KIRKLEES METROPOLITAN COUNCIL INVESTMENT & REGENERATION SERVICE

DELEGATED DECISION TO DETERMINE PLANNING APPLICATIONS TO CARRY OUT DEVELOPMENT WITHOUT COMPLIANCE WITH PLANNING CONDITIONS PREVIOUSLY ATTACHED

Reference No:	2026/70/91503/W
Site Address:	5, Woodsome Drive, Fenay Bridge, Huddersfield, HD8 0JR
Description:	Variation of condition 2 (plans) of previous permission 2024/91084 for erection of single storey rear, two storey side and two storey front extensions
Recommending Officer:	Laura Yeadon

Officer Report

title
Elevations - As Proposed

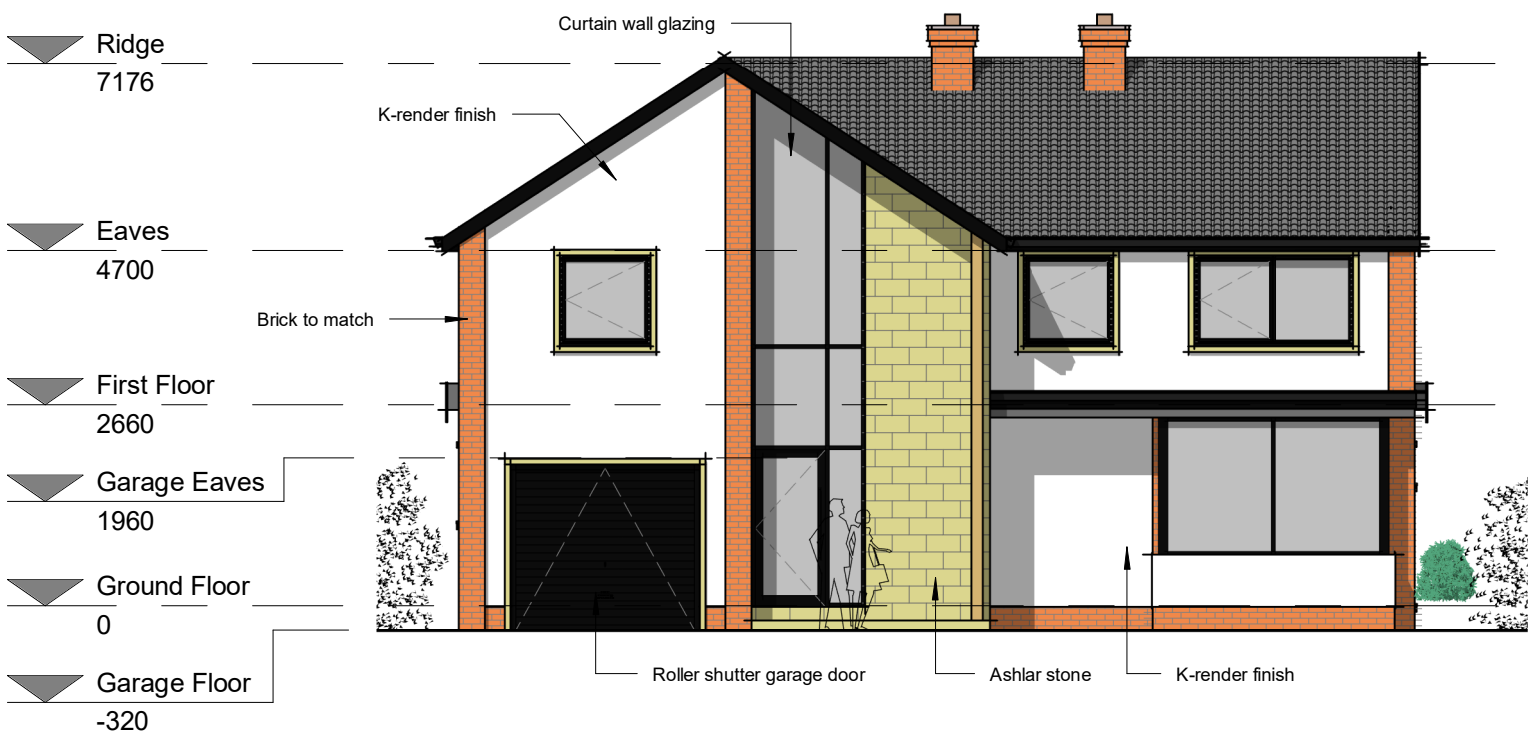
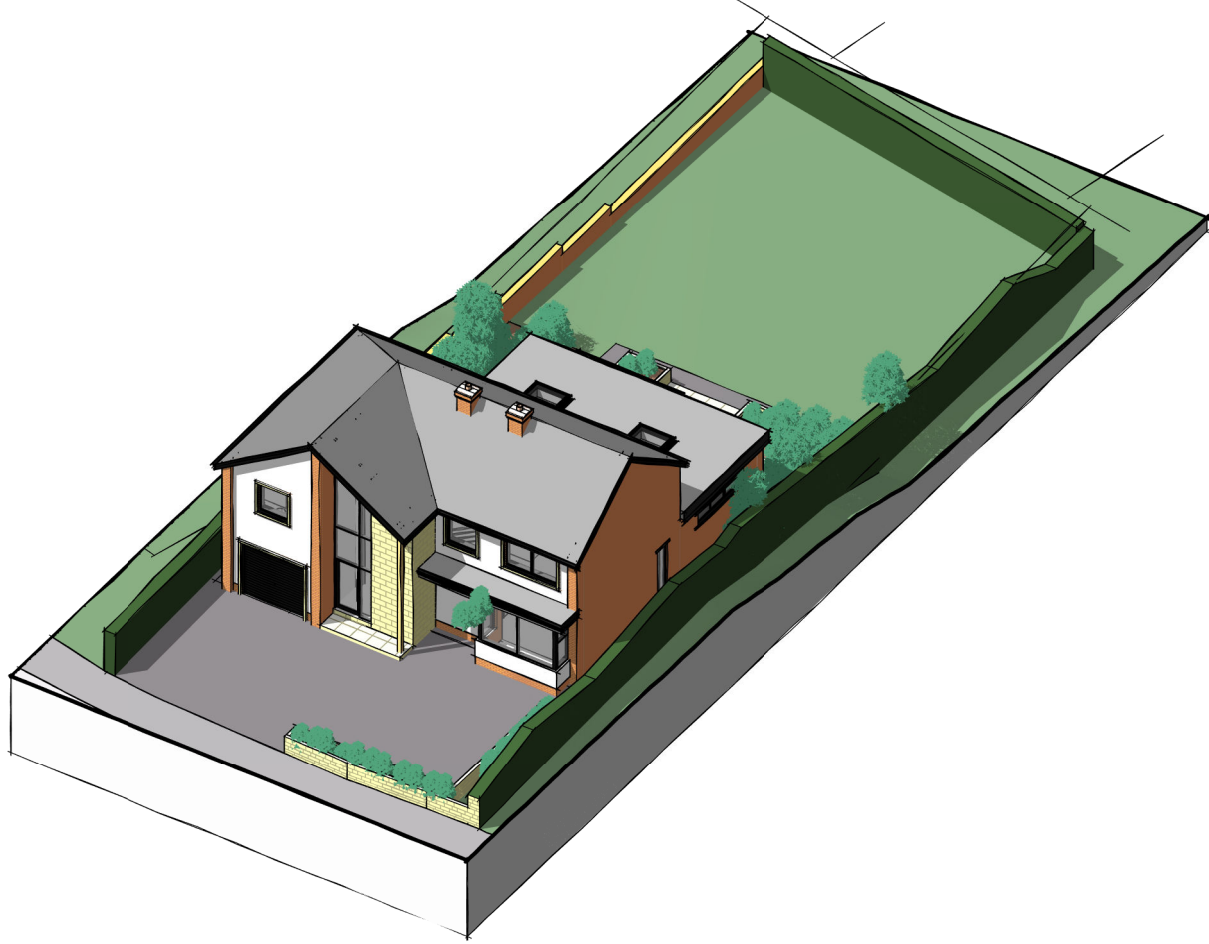
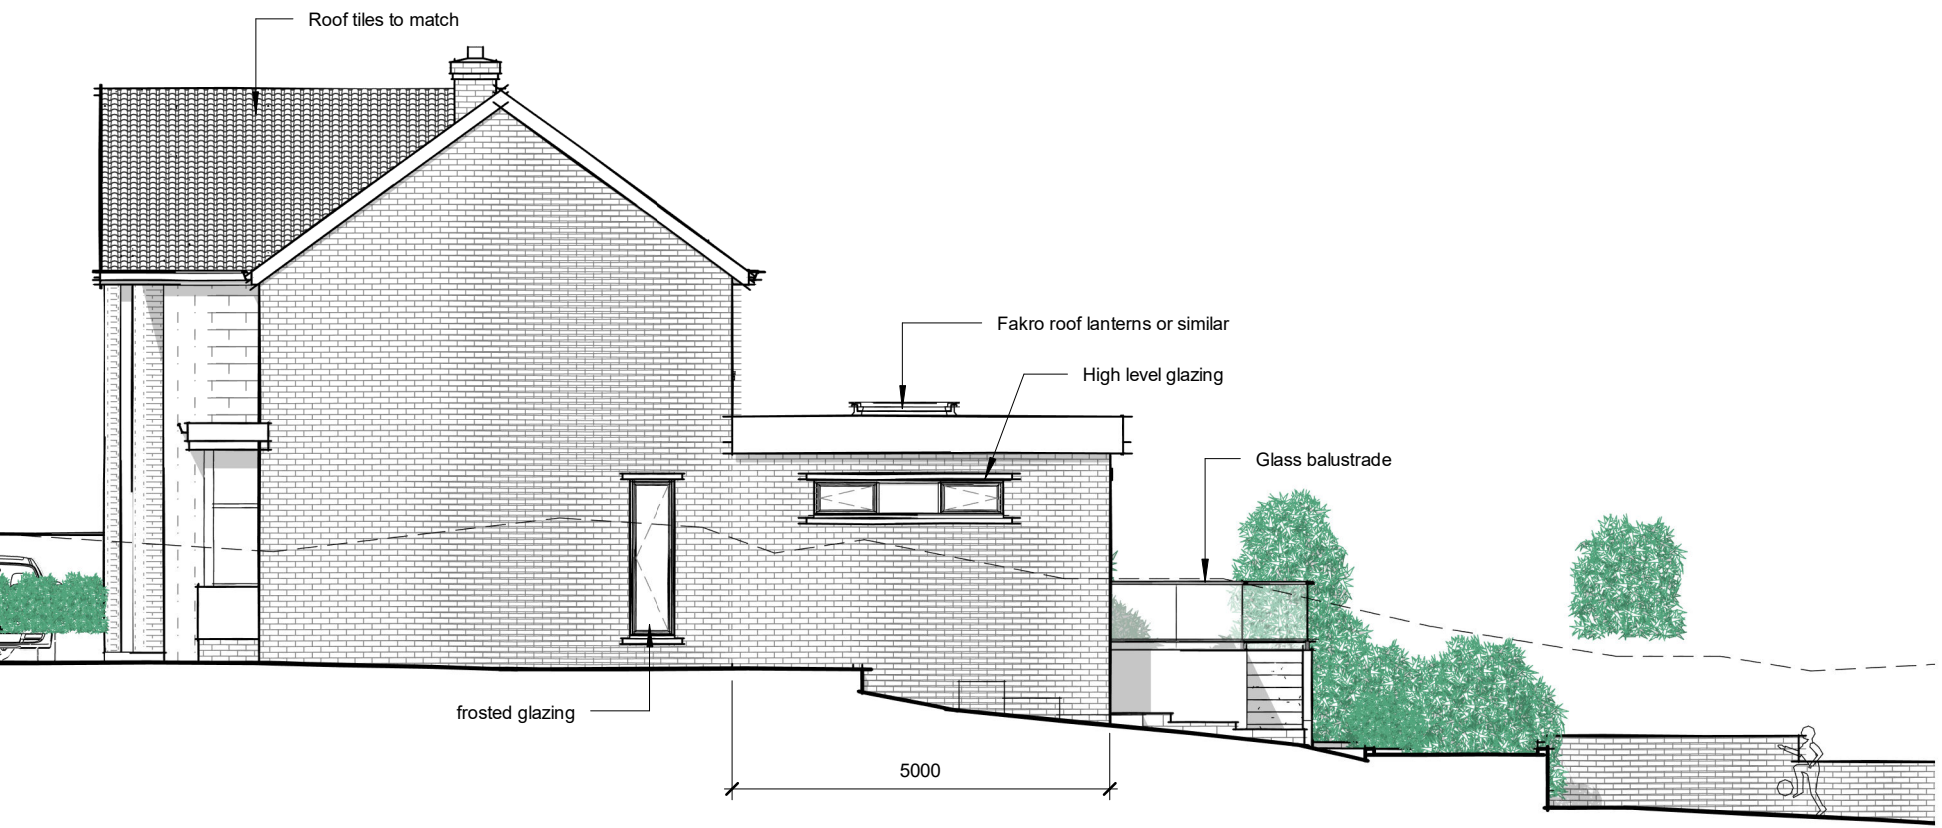
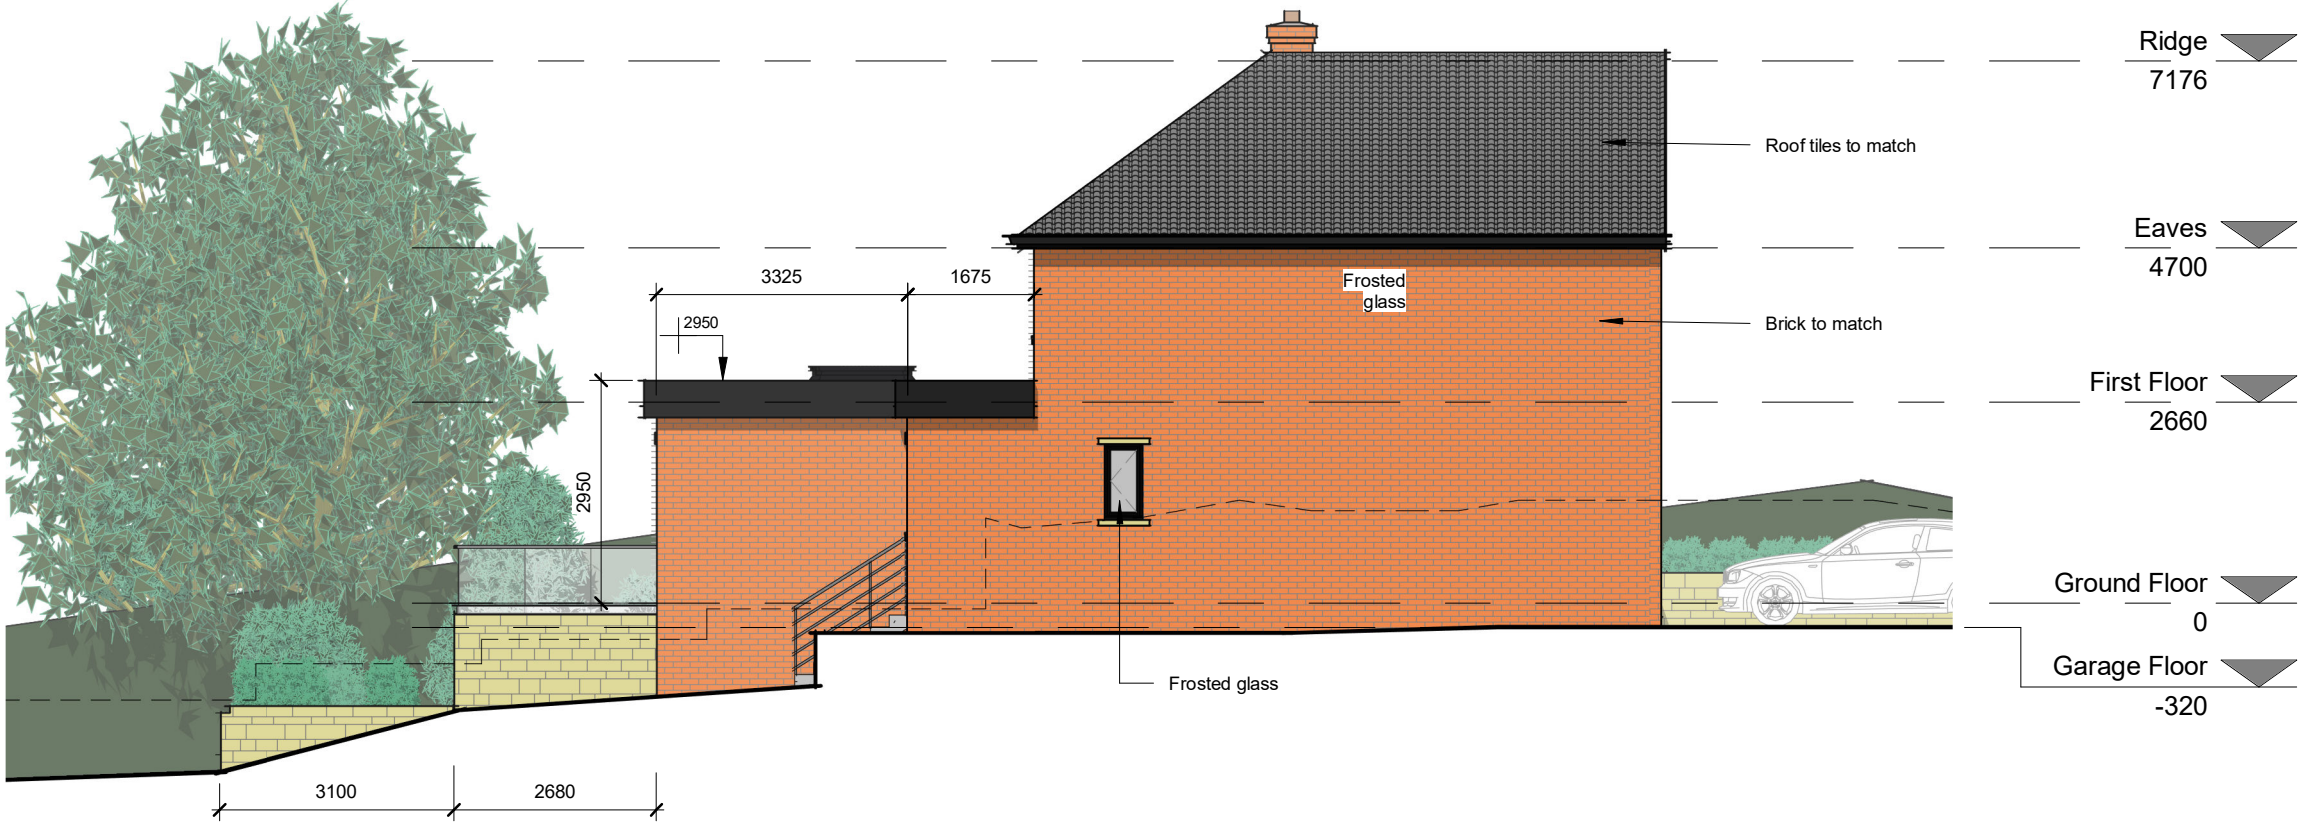
The approved plans demonstrate that the rear extension was set in from the side elevation of the property whereby the proposed plans seek to extend the width of the rear extension so that the side elevation would lie flush with the side elevation of the existing dwelling. There are no proposed alterations to the projection or height.

It is proposed that the first floor window within the two storey front extension would be changed from a double window to a single window.

It is proposed that first floor middle window configuration would be altered from a triple window to a double and single window opening.

It is proposed to insert a north facing ground floor side window to serve the study. The submitted plans indicate it will be obscure glazed.

With regards to the impact of the proposed scheme on visual amenity, the proposed increased width of the rear extension and the alterations to some fenestration details are not considered to be visually intrusive to either the host dwelling or the wider street scene over and above that already approved.

In terms of the alterations to the fenestration details to the front and rear of the property, these would not reduce and established/approved separation distances and would therefore no result in additional harm to neighbouring dwellings.

The new window to the north side facing elevation within the host property is indicated as obscure glazed and therefore raises no concern to loss of privacy.

Whilst the width of the single storey rear extension would be extended, the side elevation wall would lie flush with the existing and would not encroach further towards the neighbouring property than the existing two storey side elevation. It is also noted that the rear extension would not protrude past the rear elevation of No. 7 Woodsome Drive.
